To: Mike Rogers **From:** Mike Nugent
Fax: 774-6848 **Date:** October 10, 2002
Phone: **Pages:** 1
Re: 75 Tidemill Rd. (212 A053)

I have commenced the review of the above project and have the following comments:

TYPICAL FOUNDATION WALL SECTION - MAIN HOUSE

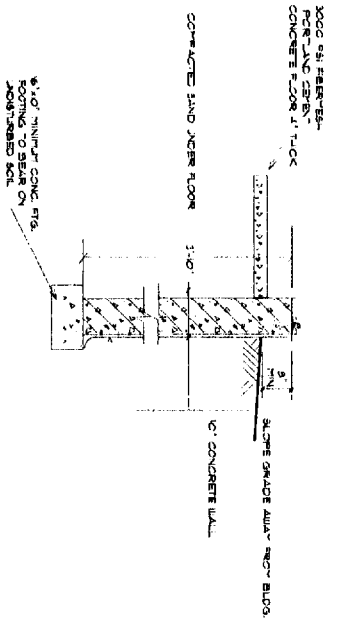
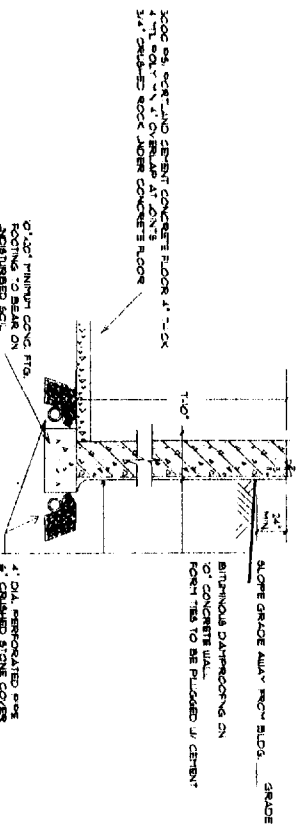
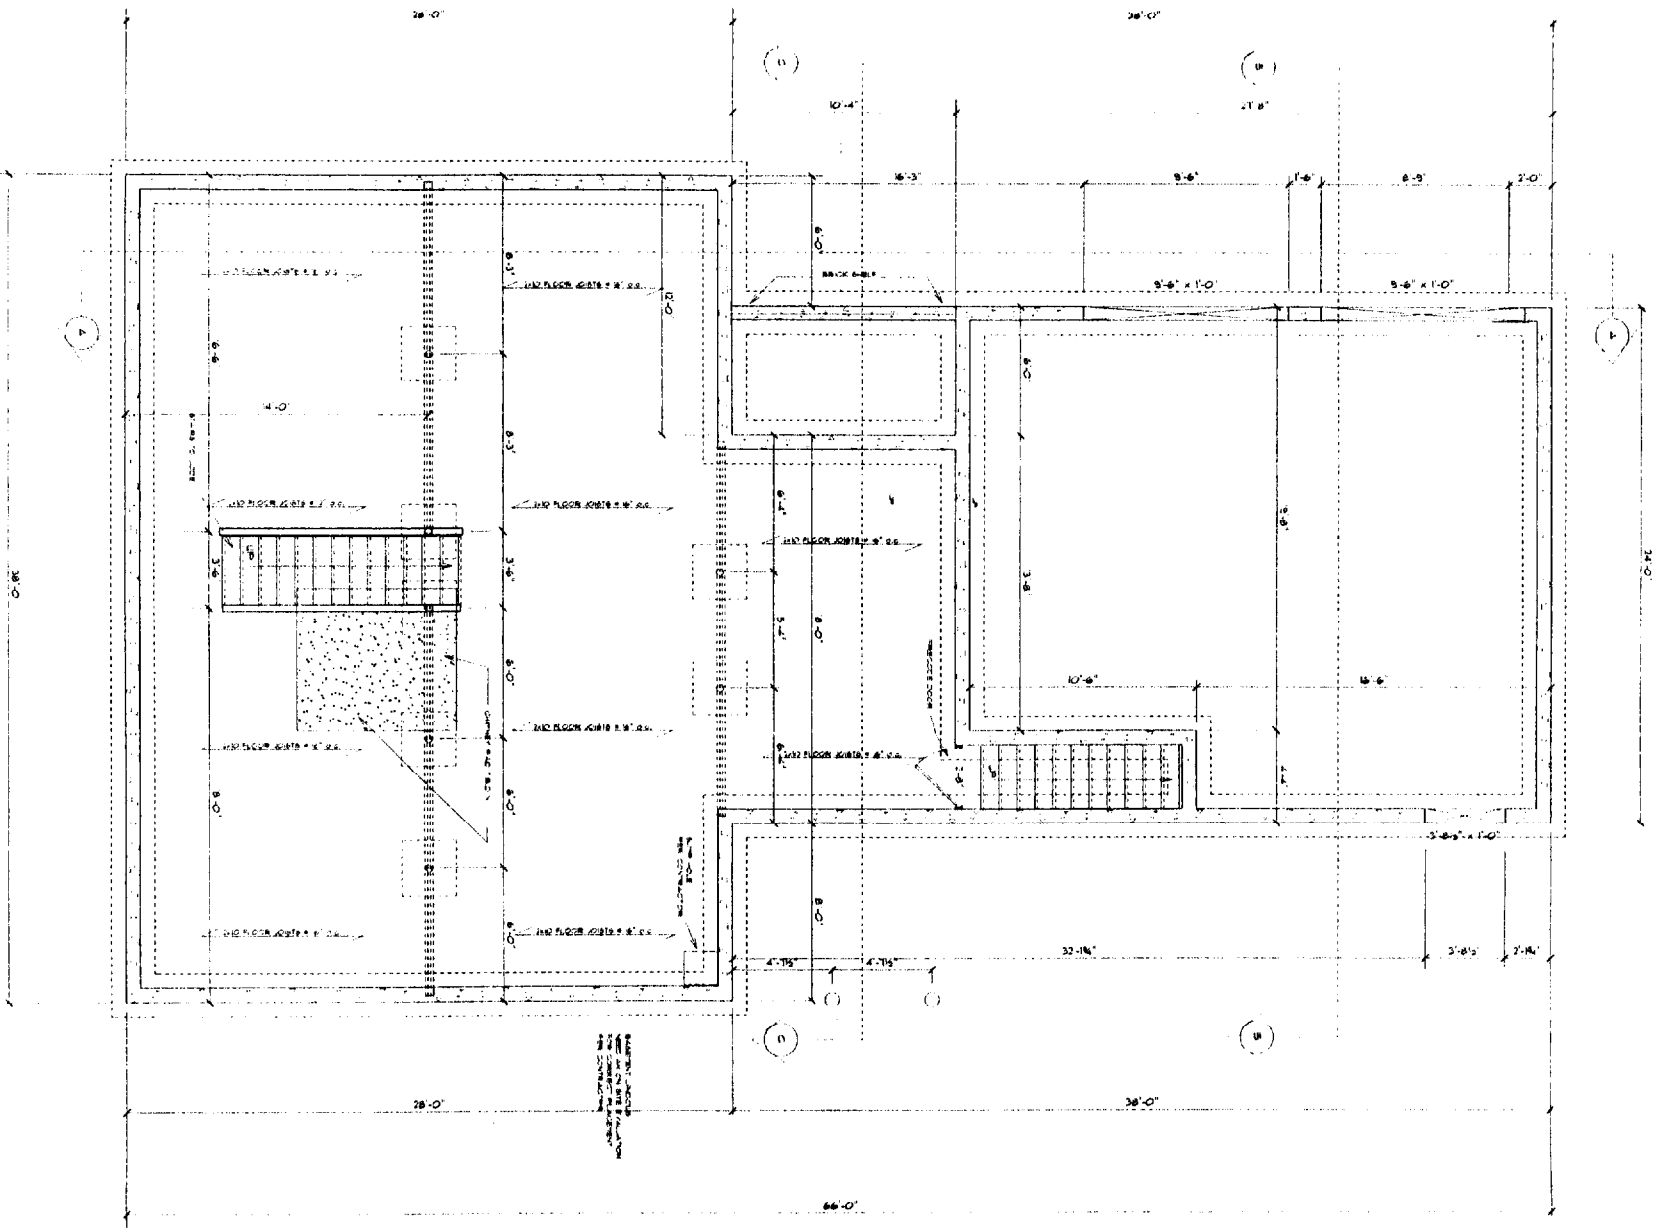
- 1) What is the soil profile on the lot?
- 2) Filter Fabric is not shown on the foundation drain, it is required.
- 3) 8" wall or 10" wall, the plans reflect both
